Ribble Valley Borough Council  
Housing & Development Control

Application no: **3/2021/0657**

Address: **10 Sawley Road Chatburn BB7 4AS**

Proposal: **Proposed boundary treatment to dwelling house approved under planning approvals 3/2019/1130 and 3/2020/0331 (Variation of Condition).**

<b>job:</b> Proposed Conversion/Rebuild of Former Filling Station Sawley Road Chatburn BB		
<b>client:</b> Mr J Butler		
<b>drawing:</b> Proposed Plans, Elevations & Site Plan		
<b>scale:</b> 1:100 @ A1	<b>date:</b> 04/20	<b>drawn:</b> smc
<b>job no:</b> 07/2020	<b>drawing no:</b> 02	<b>rev:</b> E

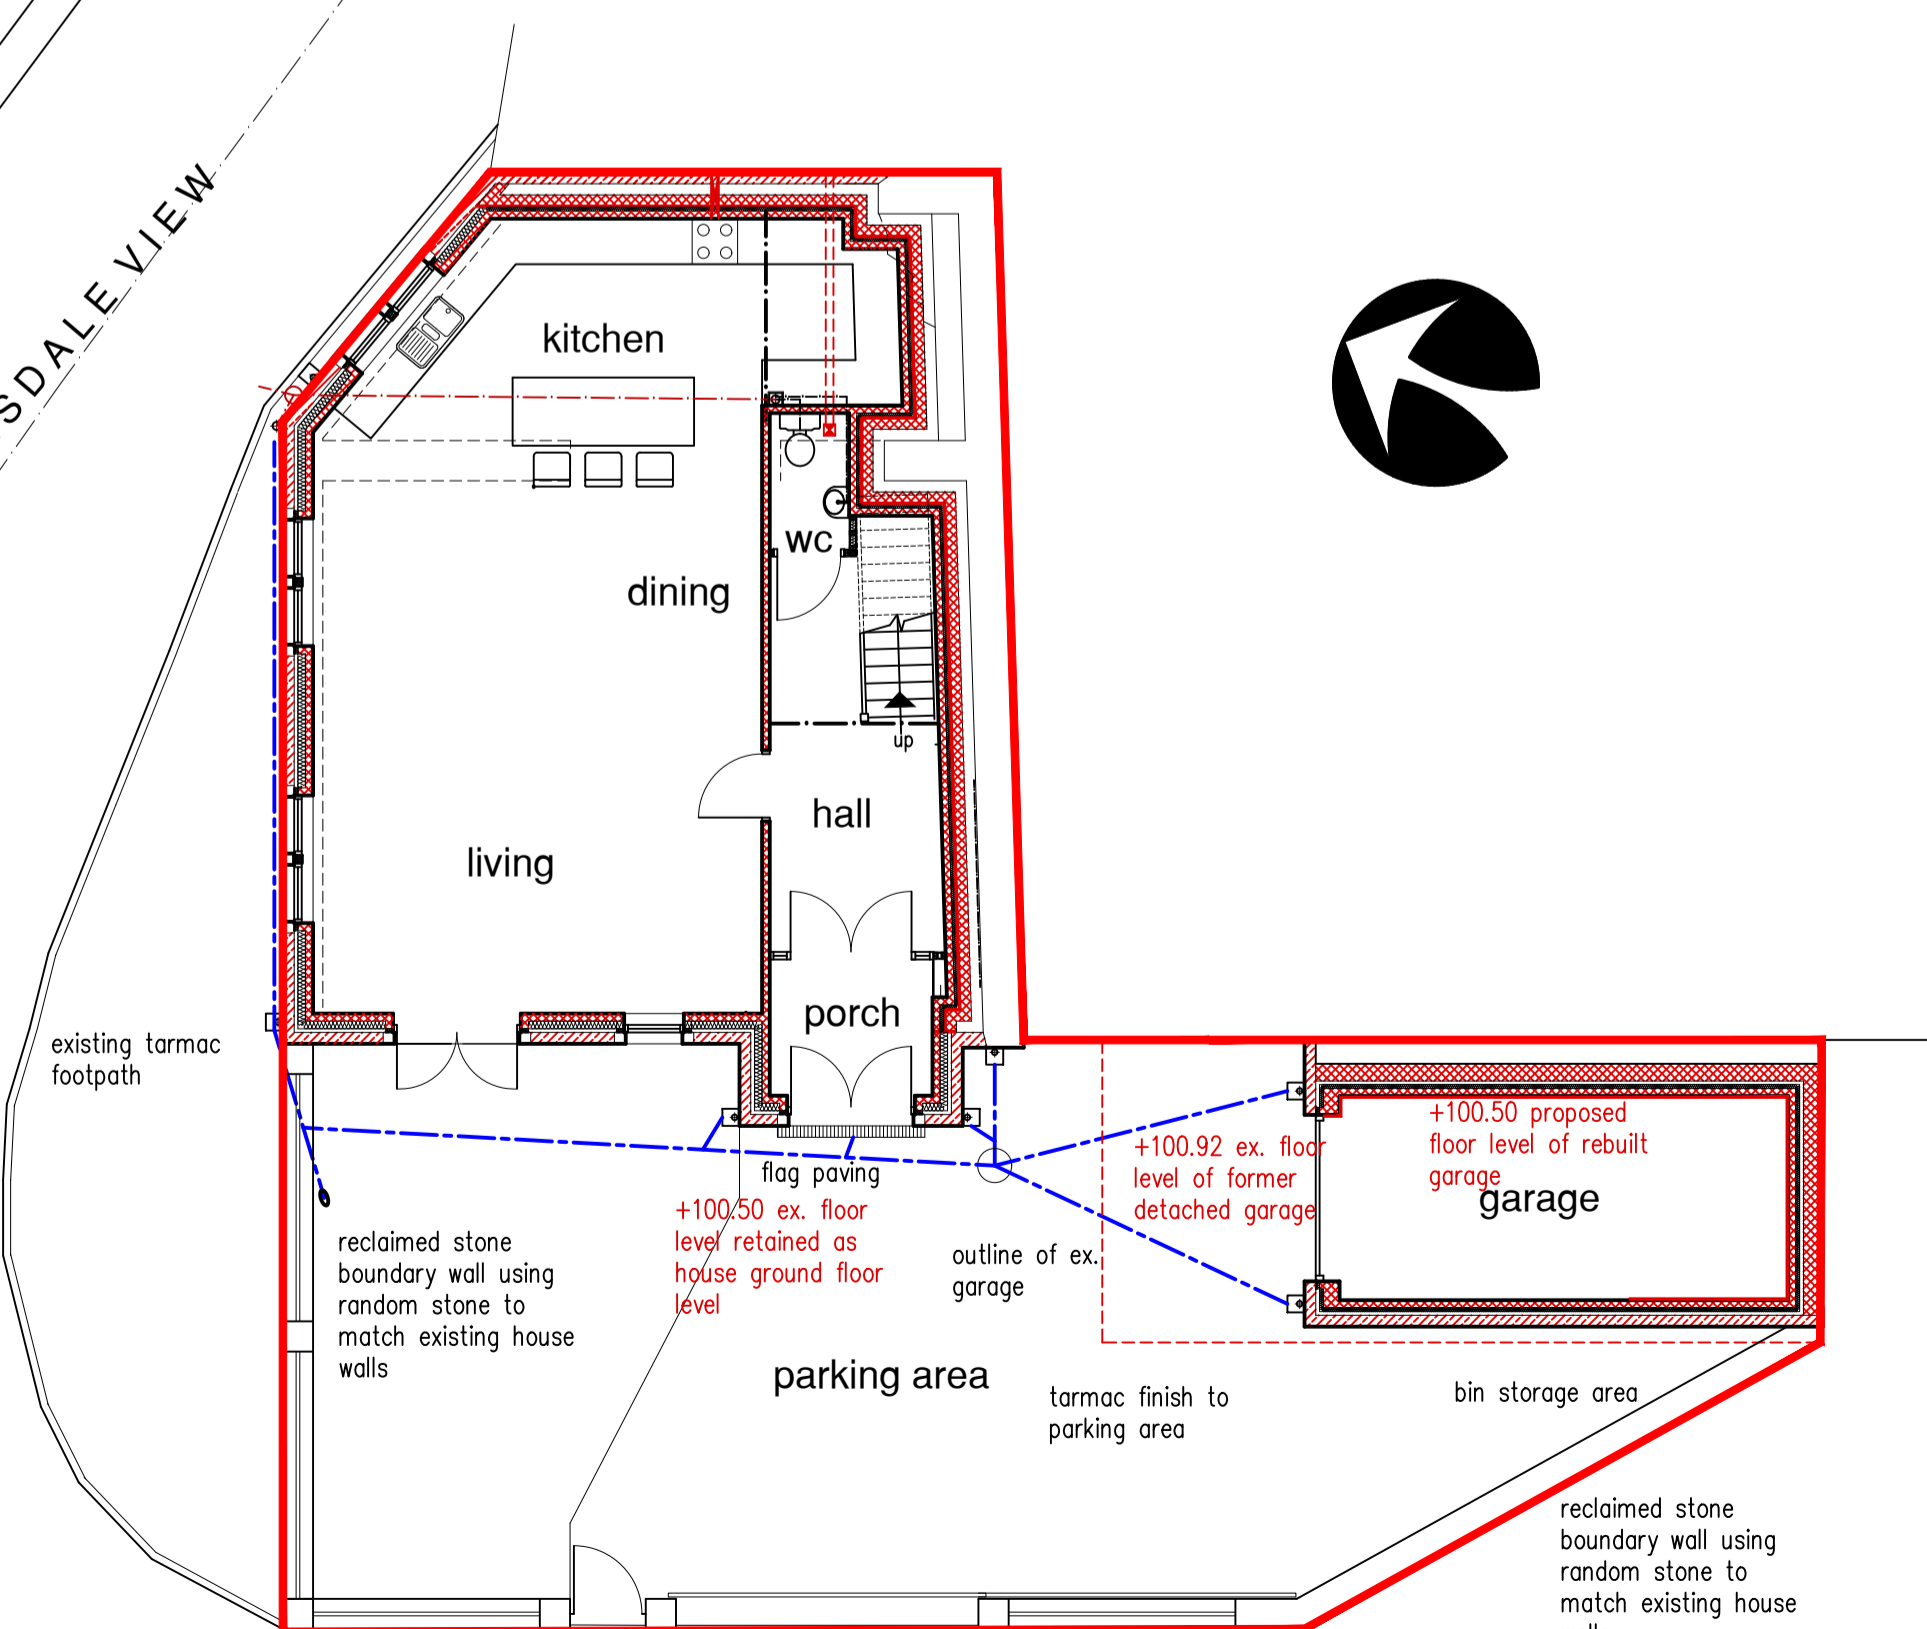
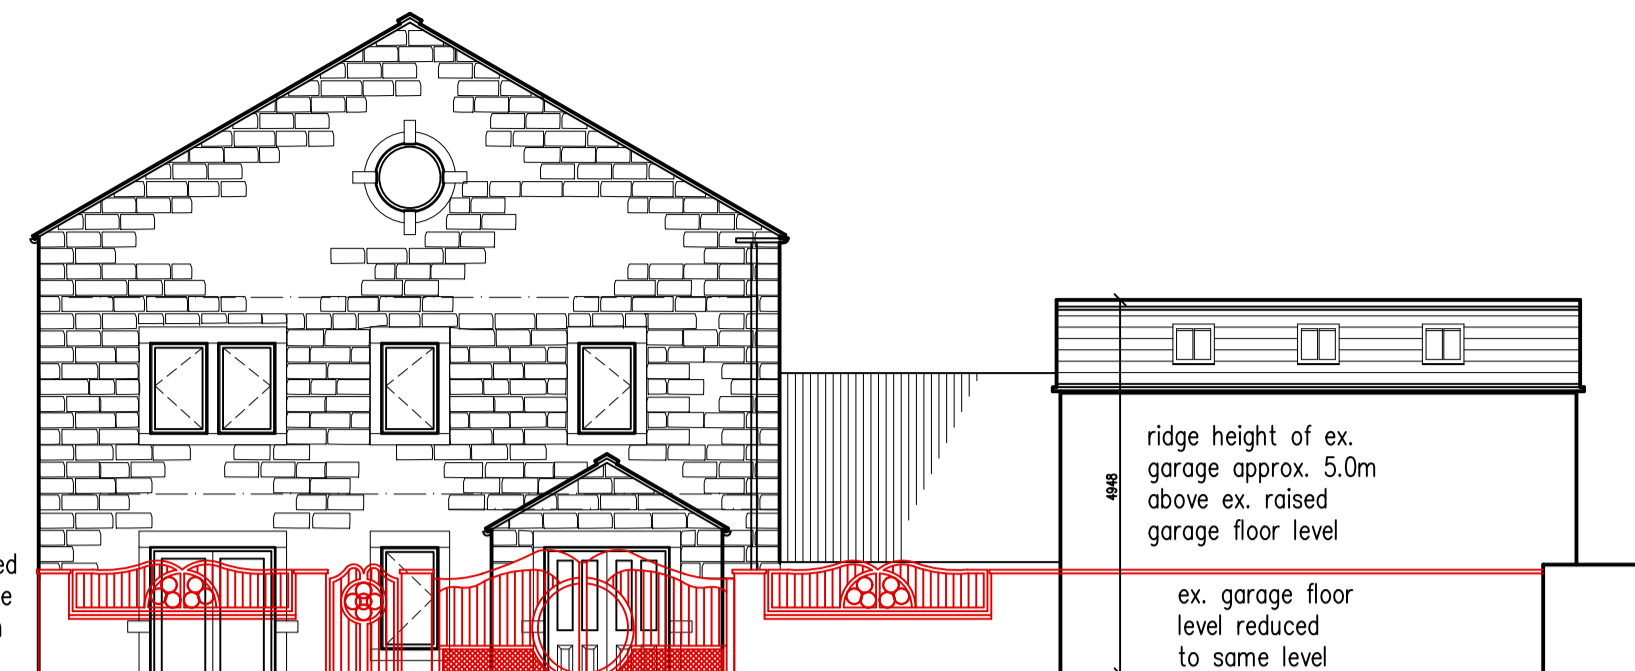
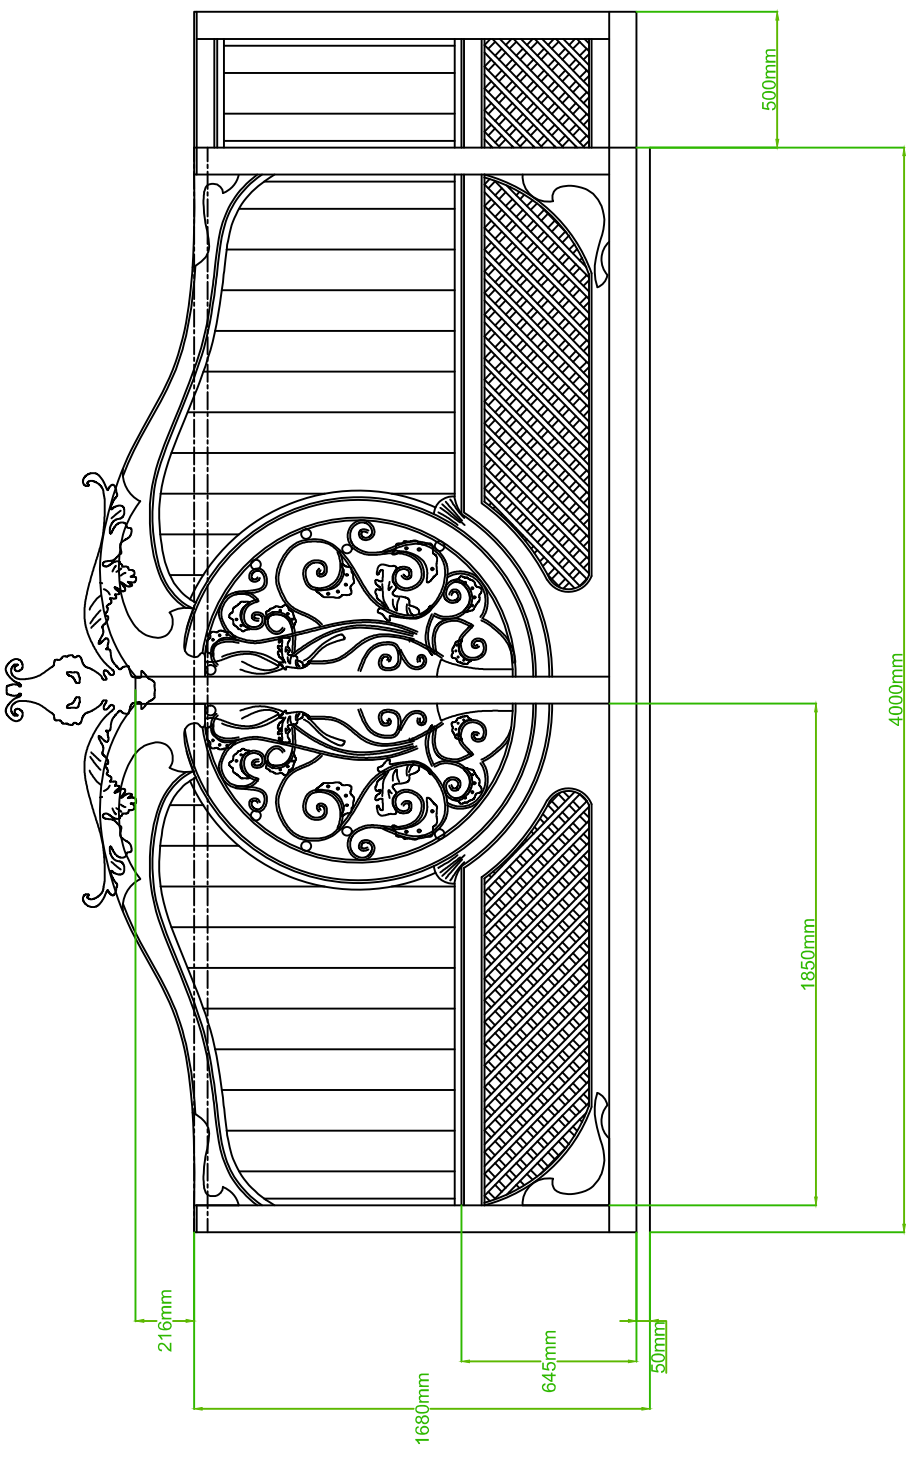
However, the LHA have reviewed Stephen Craven drawing number 02 Rev E titled "Proposed Plans, Elevations and Site Plan" and understands that the access will be gated. Normally for the LHA to accept a gated access for a single dwelling, the gate is required to be setback a distance of 5m from the public highway. The LHA have reviewed the drawing and understands that the gate will be setback a distance of approximately 0.5m from the highway. Therefore, there is a shortfall in 4.5m.

Usually the LHA would condition that the gate is setback the required distance but the LHA are aware that should the gate be setback 5m then there would be no space available on the driveway to provide off-street parking. Not only this but the access is located off a private track which is used to serve the existing garages. Therefore, with the track being private, vehicles operating the gate will not obstruct the public highway and so the LHA have no objection to the proposal.
